**To:** Andrew Simpson  
**From:** Antony Williams  
**Date:** 2 November 2021  
**Subject:** Elevation at Greystanes  
Operational Noise Impact Assessment  
Loading Dock Absorption - Warehouse 2

**At:** Aliro Group  
**At:** SLR Consulting Australia Pty Ltd  
**Ref:** 610.30454-M01-v0.1-20211102.docx

This memo provides additional information regarding the proposed loading dock absorption for Warehouse 2 at Elevation at Greystanes. This acts as an addendum to SLR Report 610.30560 – *Elevation at Greystanes, Operational Noise Impact Assessment, Warehouse 2, SSD 10399*, dated October 2021 (the SSDA Report).

EAST ELEVATION

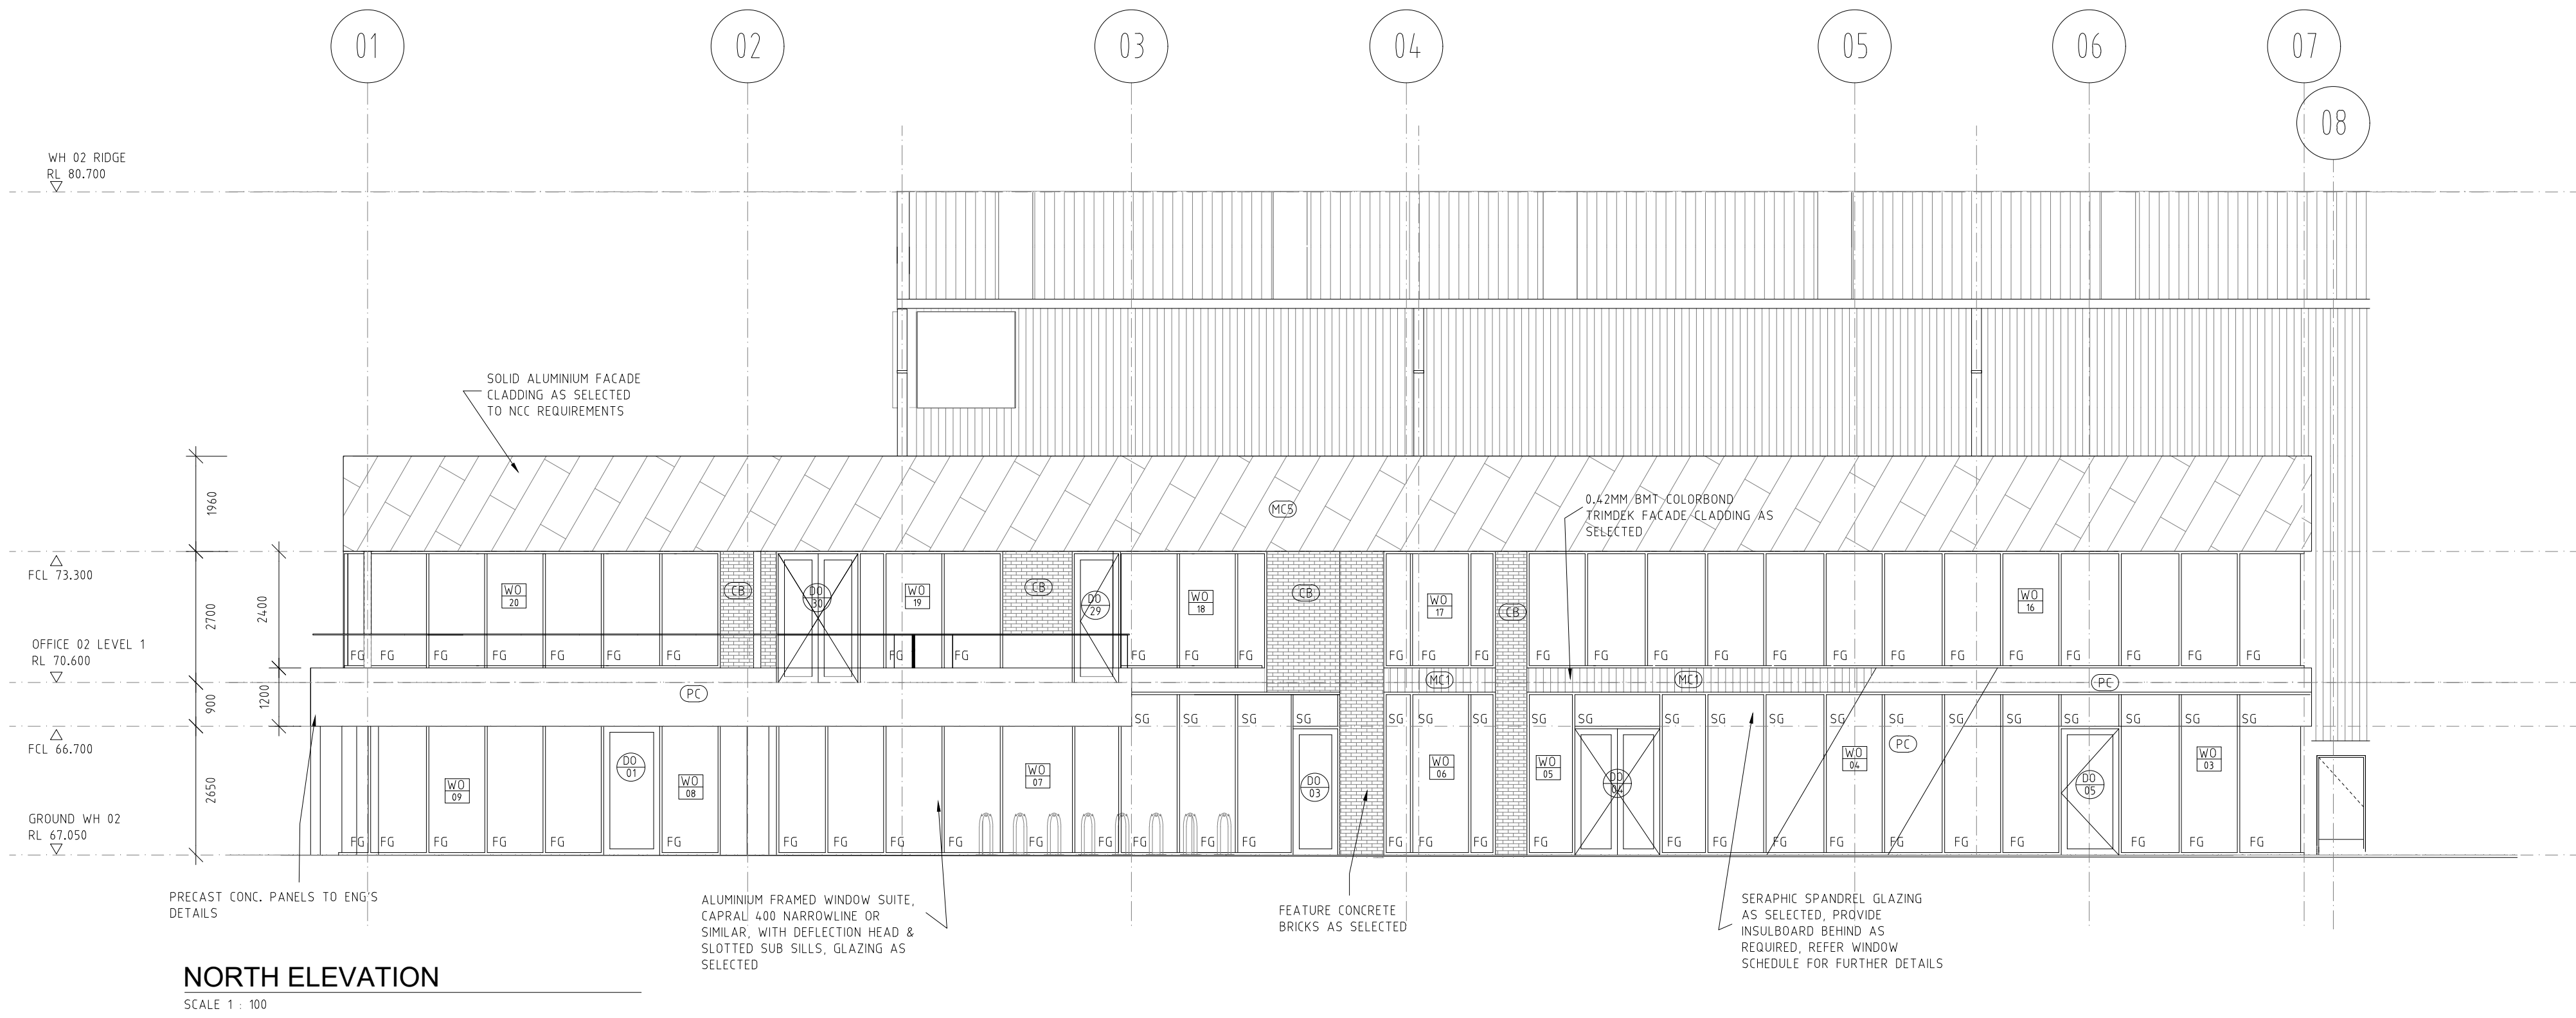
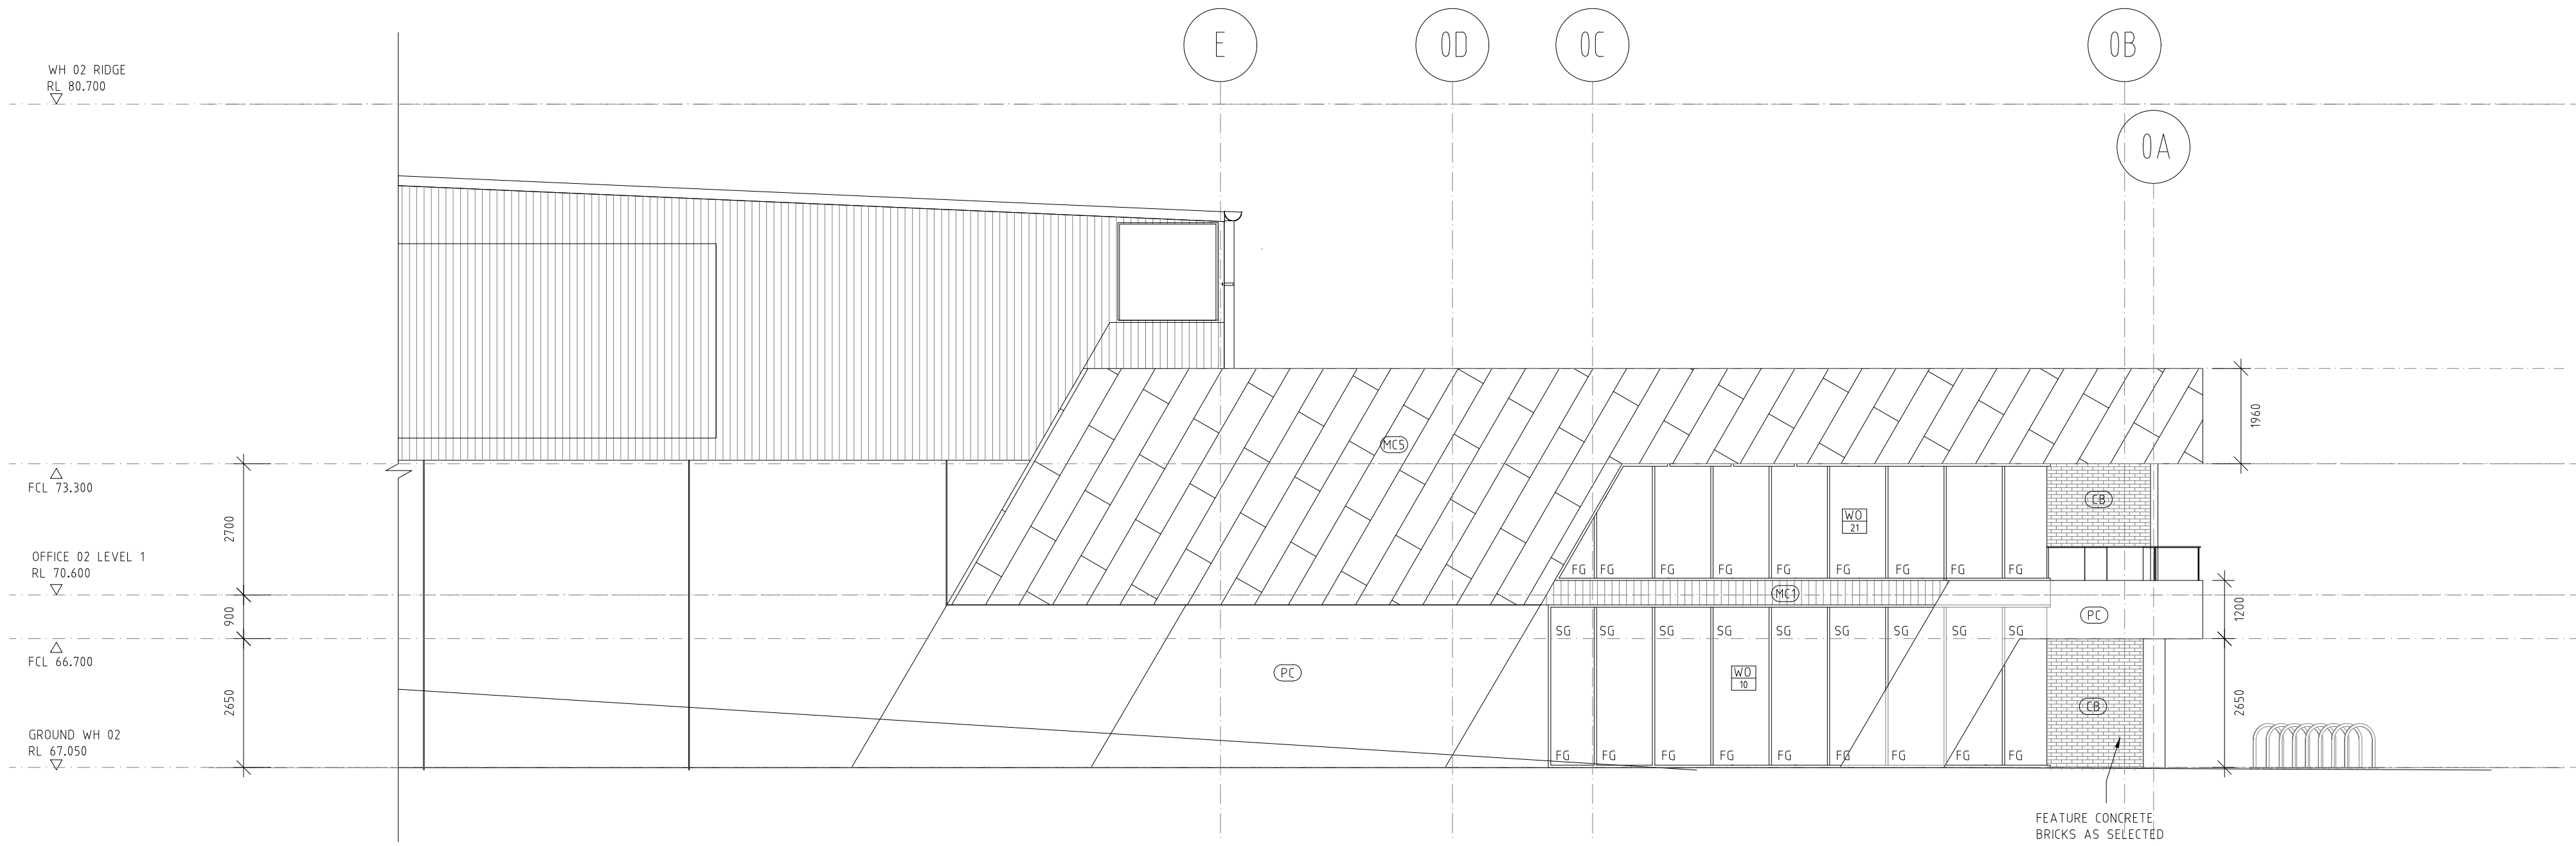
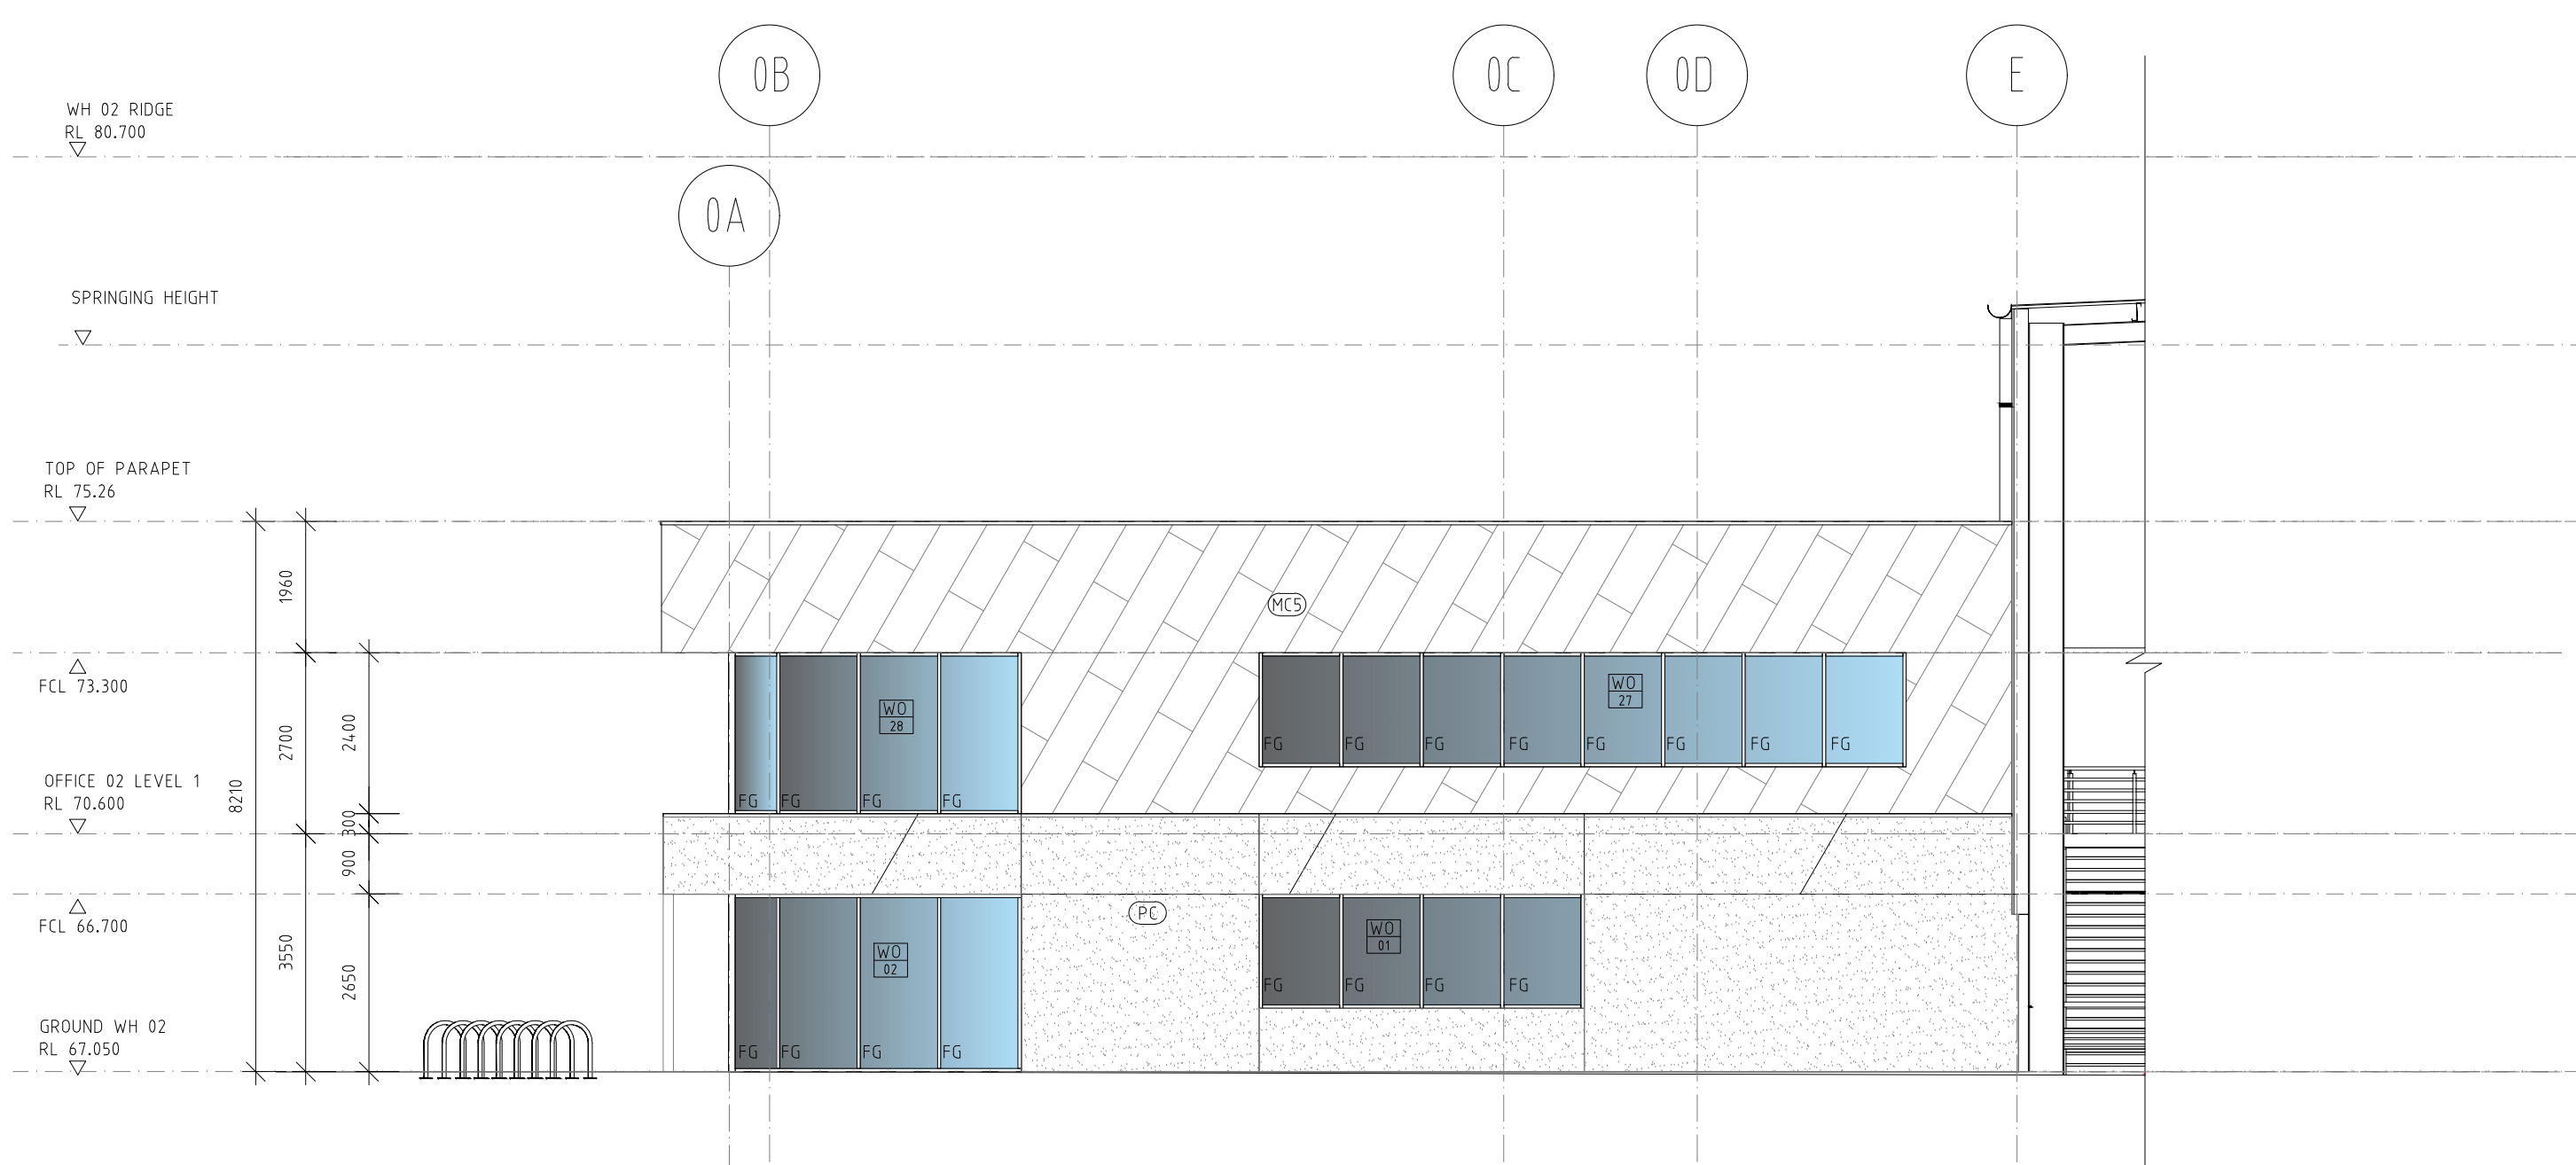
The SSDA Report recommended absorption be used in the loading dock area of Warehouse 2 to reduce noise emissions from the site. The areas where absorption is recommended to be applied are shown in red in **Figure 1** and **Figure 2**.

- Absorption applied to the eastern facade of the warehouse and underside of the canopy in the areas shown.
- The absorption should have a minimum Noise Reduction Coefficient (NRC) of 0.8. For example, this could be achieved using:
  - 75 mm thick glasswool/rockwool (hydrophobic) insulation 32 kg/m<sup>3</sup> protected by perforated steel cladding (with an open area of 11%)
  - 36 mm of Monoglass spray on insulation.
